Our Ref: BR/326/19/HH

**Town & Country Planning Act 1990 (as amended)
Town & Country Planning (Development Management Procedure) (England) Order 2015
Application for Planning Permission for Works or Extension to a Dwelling**

Development New entrance to flat.
Location Flat 68A Aldwick Road Bognor Regis

SITE PLAN 1:500

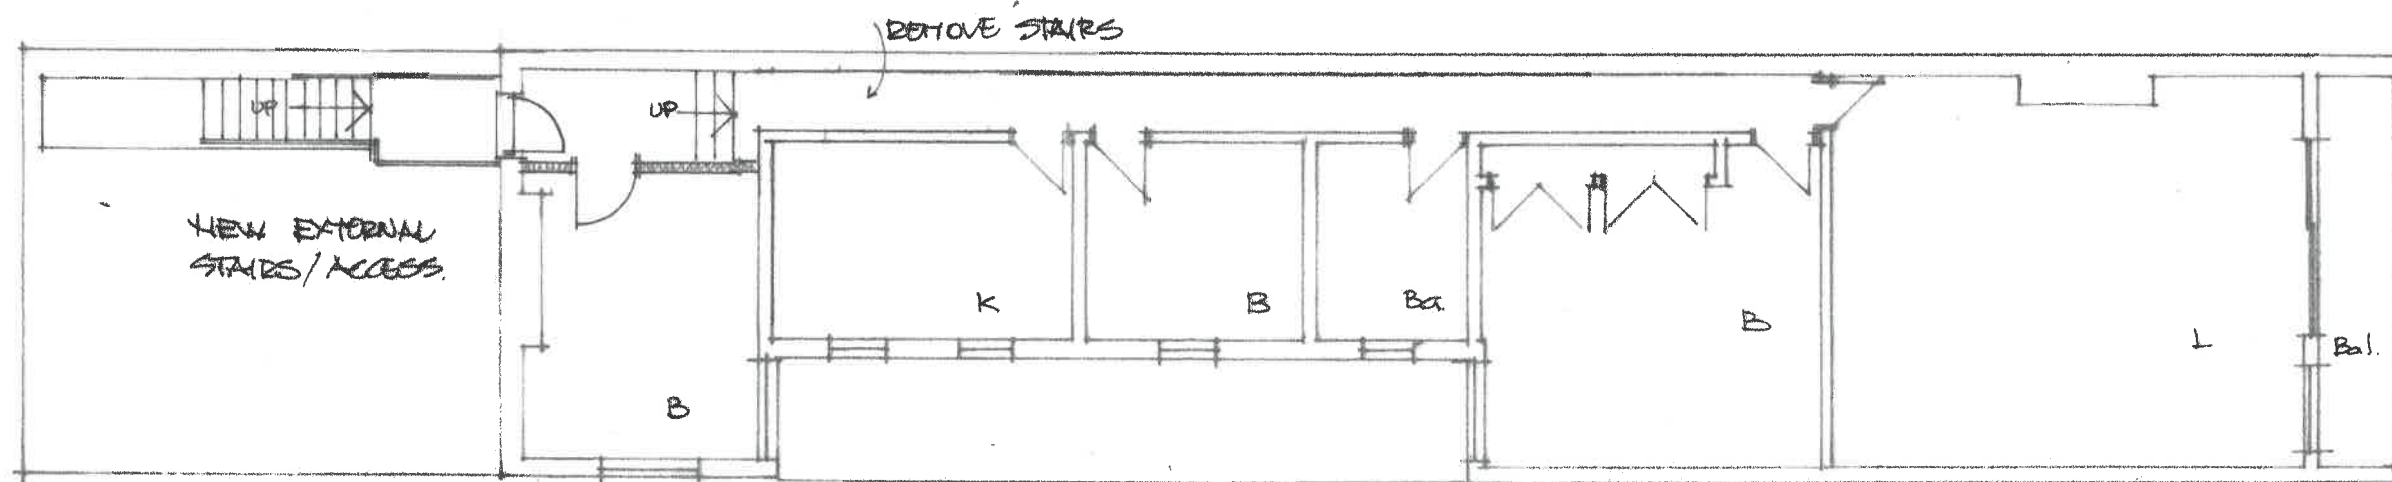
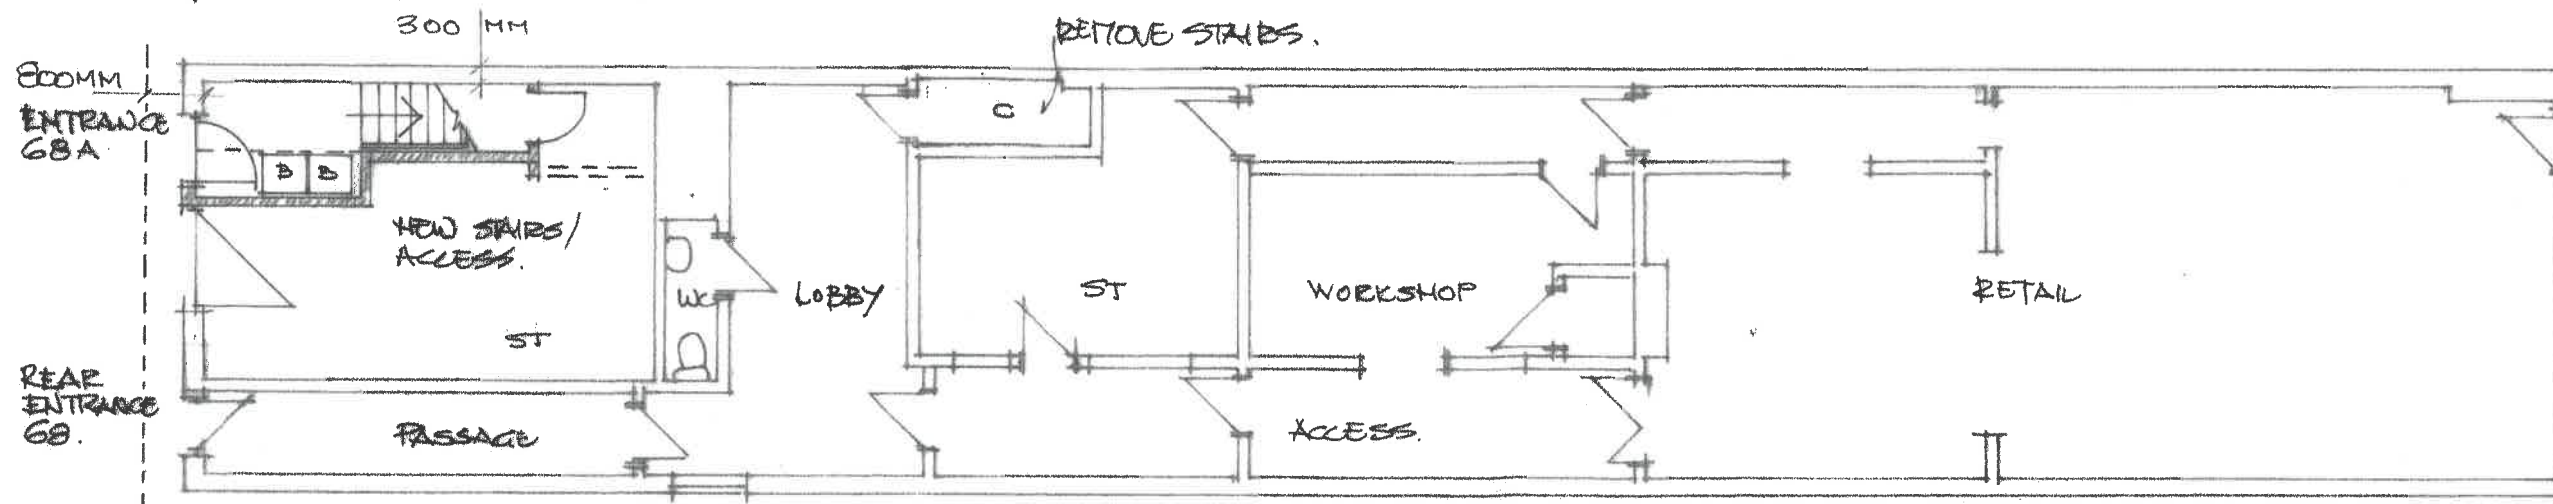
Please amend the Block Plan to show the proposed development in relation to the site boundaries. Written dimensions to boundaries are also required.
